DEVELOPMENT REVIEW BOARD - HYDROLOGY SECTION
 Ernest Armijo, P.E., Principal Engineer 924-3986 earmijo@cabq.gov

DRB Project Number: <u>2019-002046</u>		Hearing Date: <u>2-26-2020</u>	
Project: <u>SWMD Admin & Maintain, Edith</u>		Agenda Item No: <u>2</u>	
<input type="checkbox"/> Sketch Plat	<input type="checkbox"/> Minor Preliminary / Final Plat	<input type="checkbox"/> Preliminary Plat	<input type="checkbox"/> Final Plat
<input type="checkbox"/> Temp Sidewalk Deferral	<input type="checkbox"/> Sidewalk Waiver/Variance	<input checked="" type="checkbox"/> Site Plan	<input type="checkbox"/> Bulk Land Plat
<input type="checkbox"/> SIA Extension	<input type="checkbox"/> DPM Variance	<input type="checkbox"/> Vacation of Public Easement	<input type="checkbox"/> Vacation of Public Right of Way

CONCEPTUAL GRADING & DRAINAGE PLAN

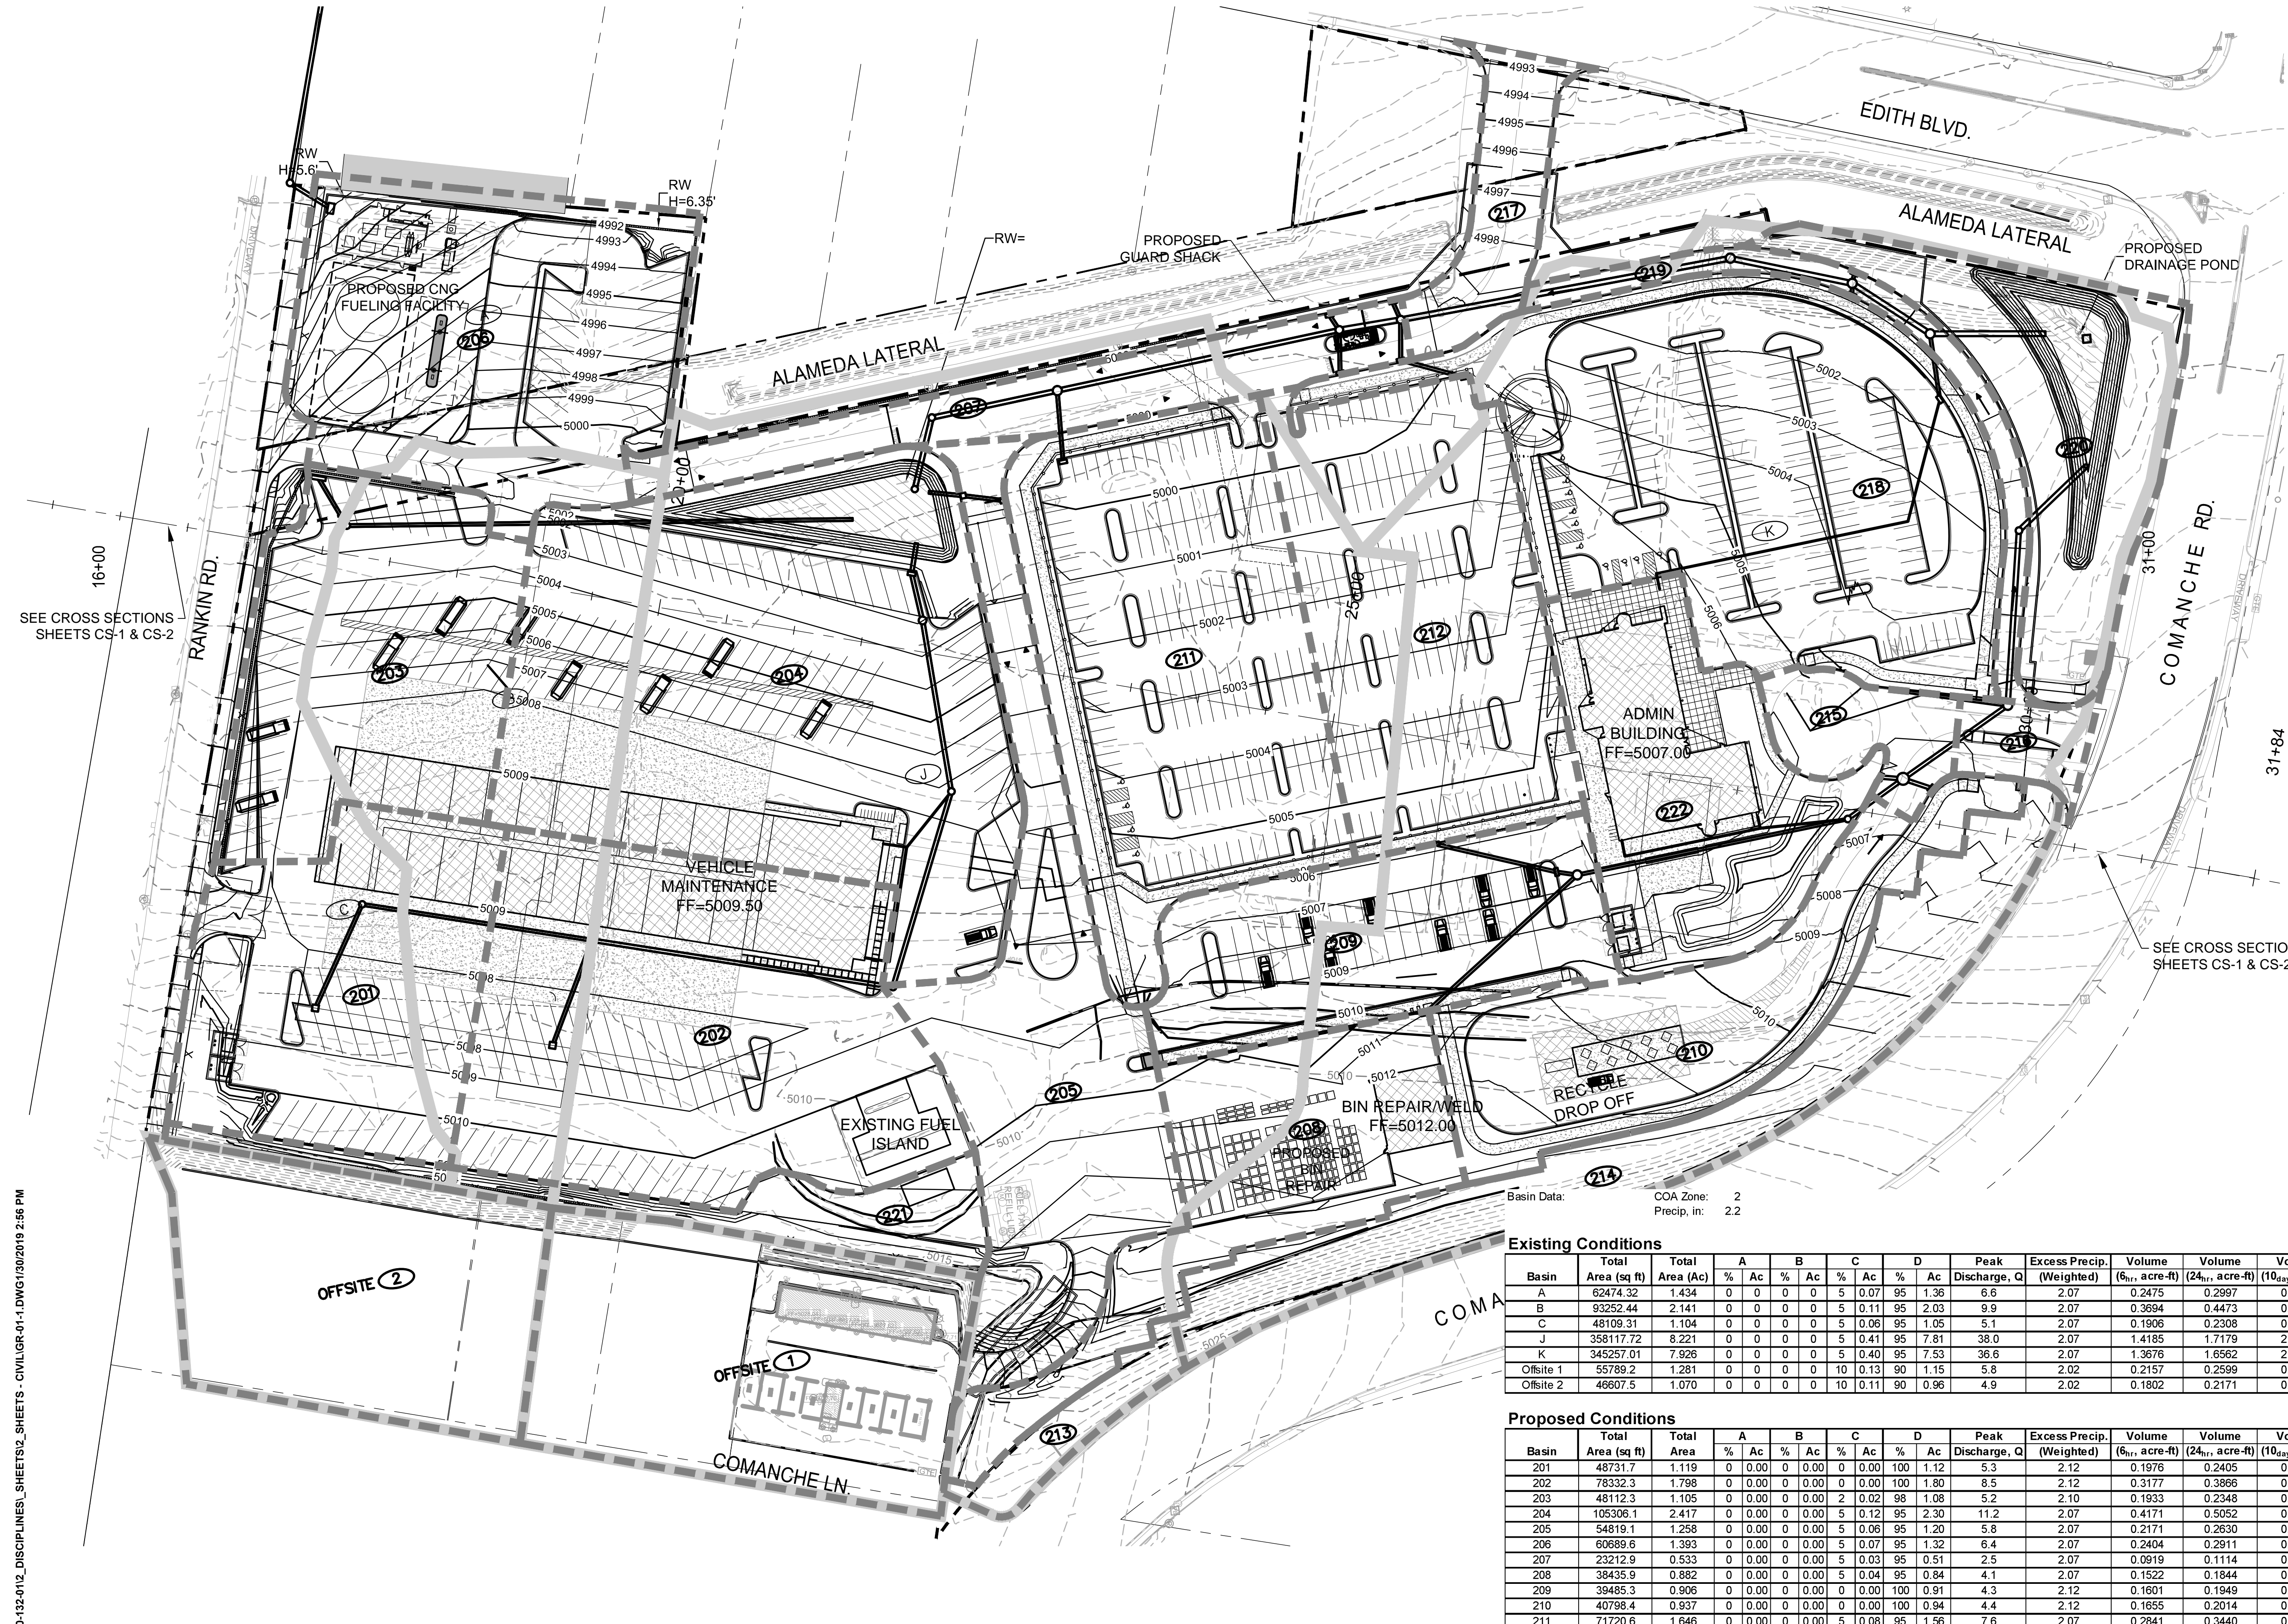
- An approved Conceptual G&D Plan is required. The last review was completed 5/28/2019 with no response yet.
- It appears that right of way dedication is needed along Rankin Rd. to contain the new C&G and Sidewalk. I see right of way on the Plat, but a width is not indicated other than along northerly lot lines which are not perpendicular to the dedication. Please show the dedication on the Site Plan and on the Plat listing the width.
